From: [REDACTED]
To: [Norfolk Boreas](#)
Subject: Boreas Project EN10087.
Date: 19 December 2019 19:07:02

Q3.0.1. Compulsory acquisition schedule.

Title:	Scenario 1 Viewpoint 2: Lodge Lane South
--------	--

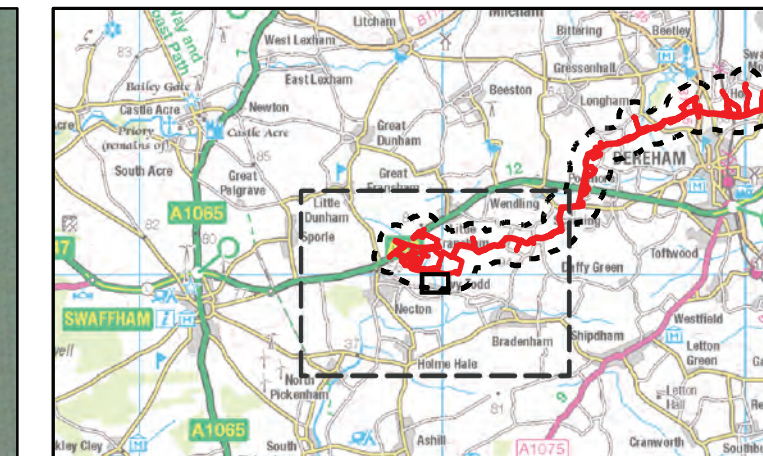
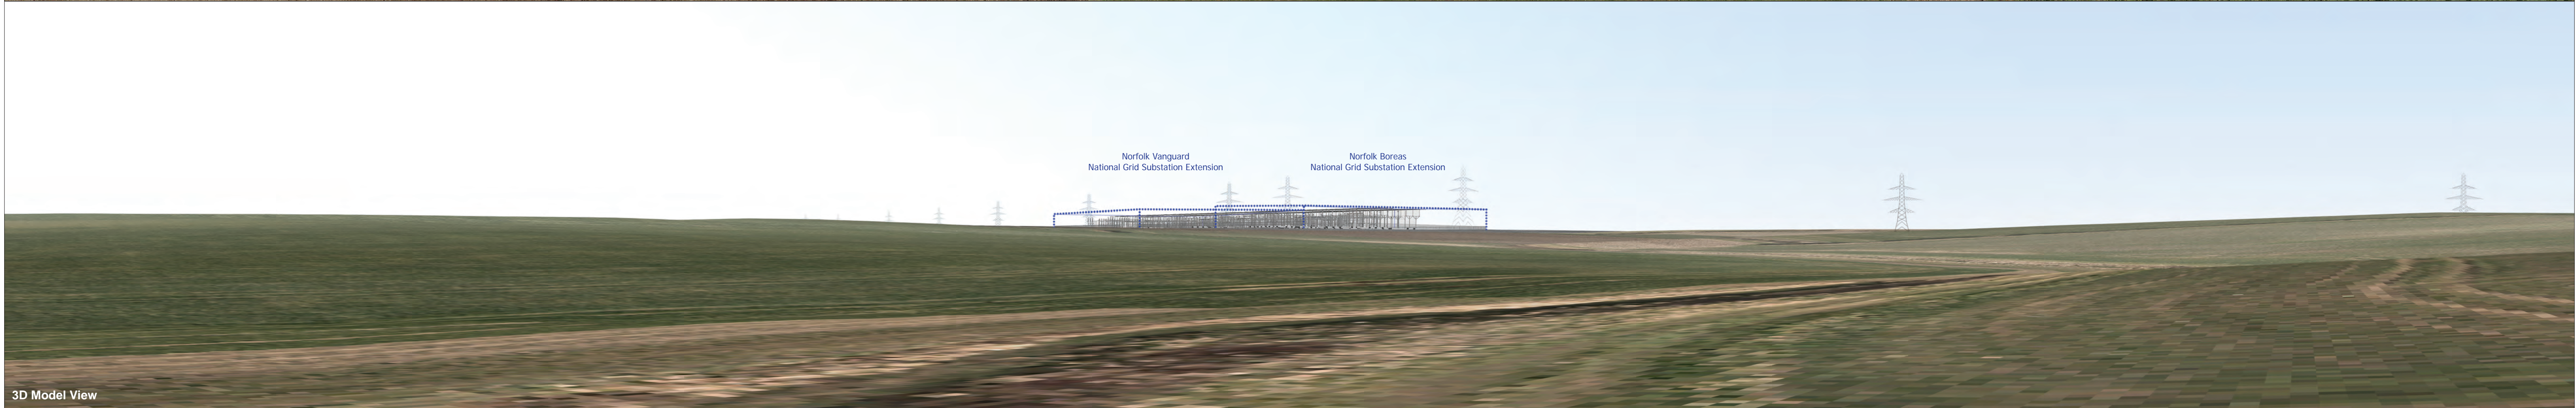
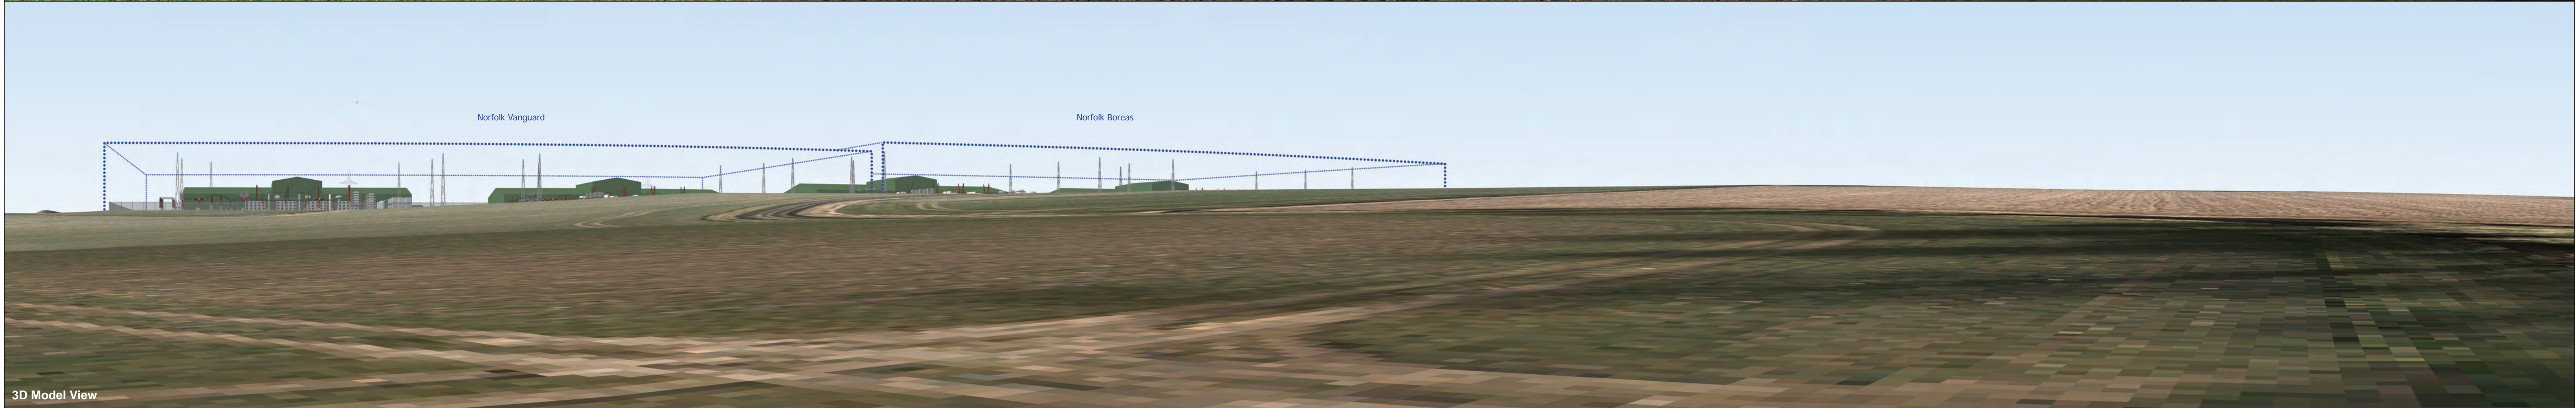
I have included three photographs looking at the south boundary of the substation site. The first photo shows Lodge Farm trees on the left, which the substation would be behind, but would be double their height, and Necton Wood to the right, which the substation would be in front of.

The third shows the existing landscape, where Boreas is proposed. I feel higher planted mounds would fit well with near and far wooded areas. Every effort is made to negate negative effects on environmental matters, equal respect should be shown to affected residents.
